From: [REDACTED]
To: [M25 Junction 28](#)
Subject: M25 Junction 28 improvement scheme - TfL attendance at Compulsory Acquisition Hearing 1
Date: 24 February 2021 13:38:22

TfL notes the proposed agenda for Compulsory Acquisition Hearing 1 for the M25 Junction 28 improvement scheme examination and that matters concerning TfL's land interests are not proposed for discussion at the hearing.

Drawing Title:	LAND PLANS REGULATION 5(2)(i) Sheet 1 of 4
Drawing Number:	TR010029/APP/2.2
HE PIN: HE551519	Scale: 1:2,500
Original Size: A1	1

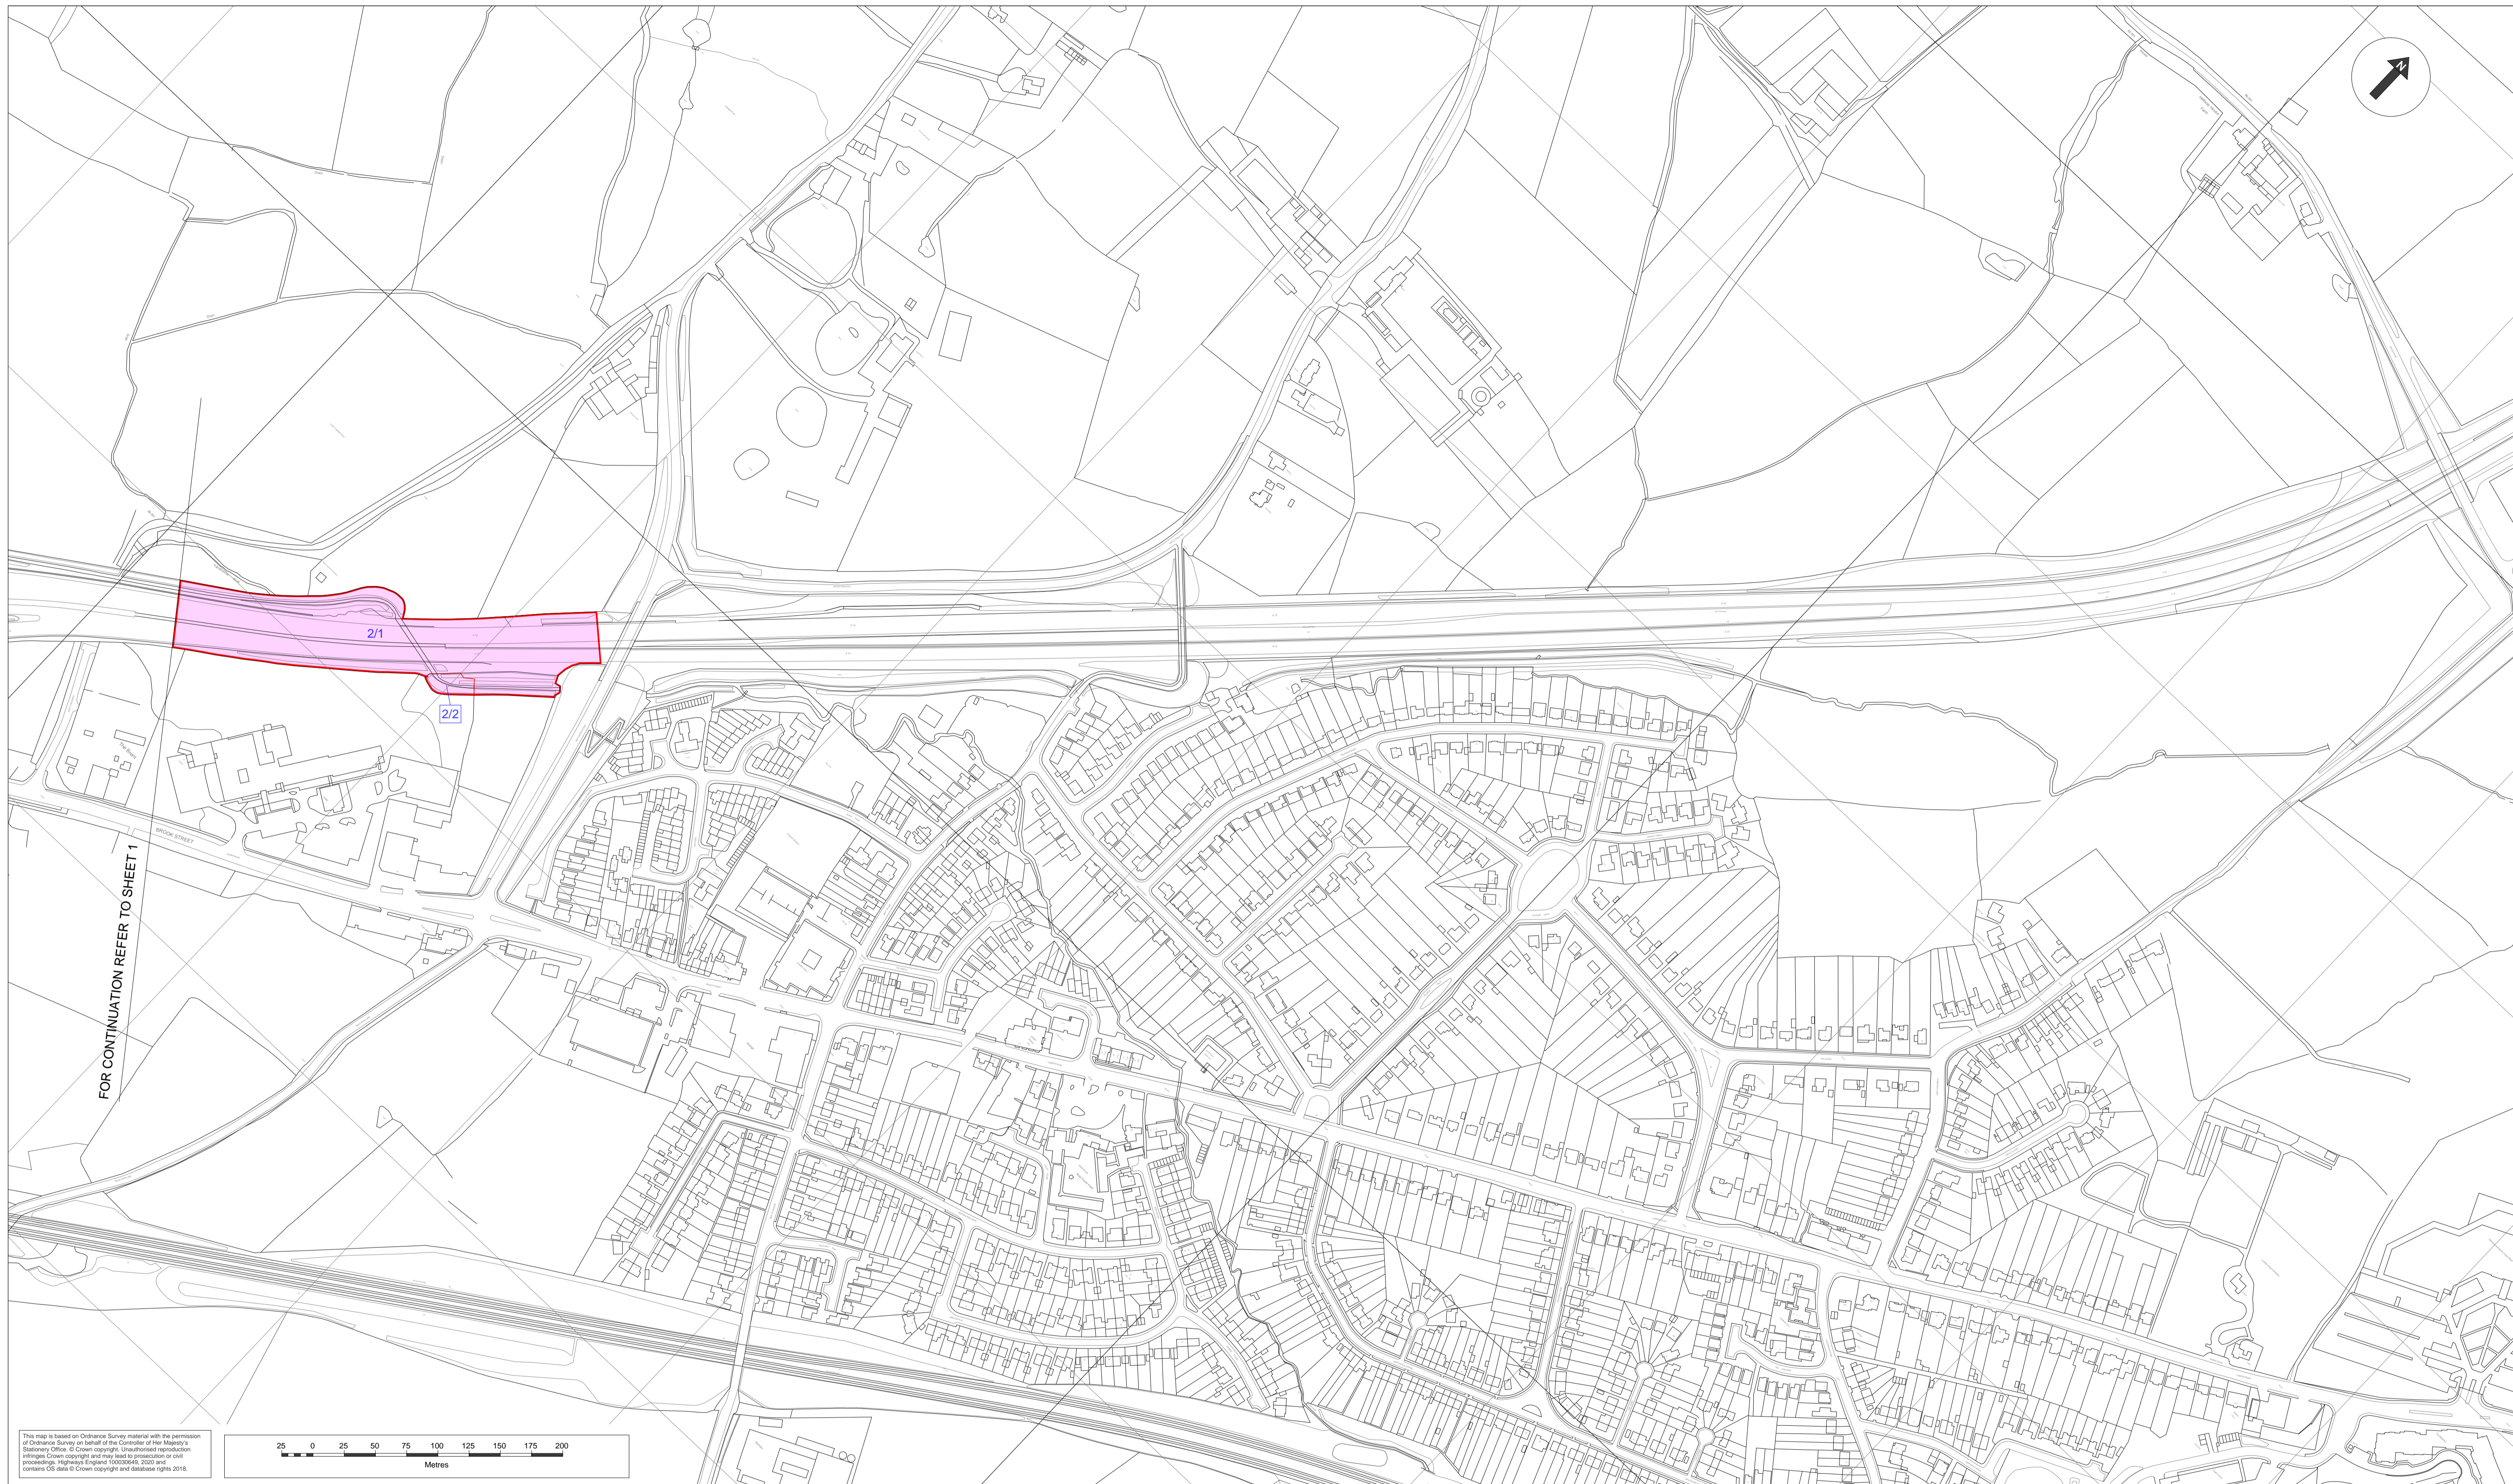
- Plot 1/1a – acquisition of permanent rights and temporary possession is sought by the Applicant. TfL remains unclear of the reasons why permanent rights are sought over the majority of this plot rather than just temporary possession and no need or justification has been provided to TfL by the Applicant. TfL considers that the only part of this plot where permanent rights may be required is a small part of the plot affected by the diversion of the gas pipeline. The Applicant shared the draft Land Plans with TfL on 11 February and TfL responded on 12 February welcoming the sub-division of plots but raising this concern about rights sought over Plot 1/1a. TfL is therefore not in agreement with the Applicant on this matter.

- Plot 1/3 – acquisition of all interests and rights is sought by the Applicant. This land is wholly in TfL ownership and is required to deliver the new A12 eastbound off slip road which the draft DCO specifies will be TfL's responsibility. TfL is therefore unclear why acquisition of all interests and rights in this plot of land is required to deliver the Proposed Scheme, since it is currently in TfL's ownership and will need to be in TfL's ownership following completion of the Proposed Scheme.

- Plot 1/6 – acquisition of permanent rights and temporary possession is sought by the Applicant. TfL welcomes its addition as an occupier (as highway authority) in the updated Book of Reference. However, TfL is unclear of the reasons why permanent rights are sought over this plot rather than just temporary possession as TfL will remain the highway authority over this plot following the development.
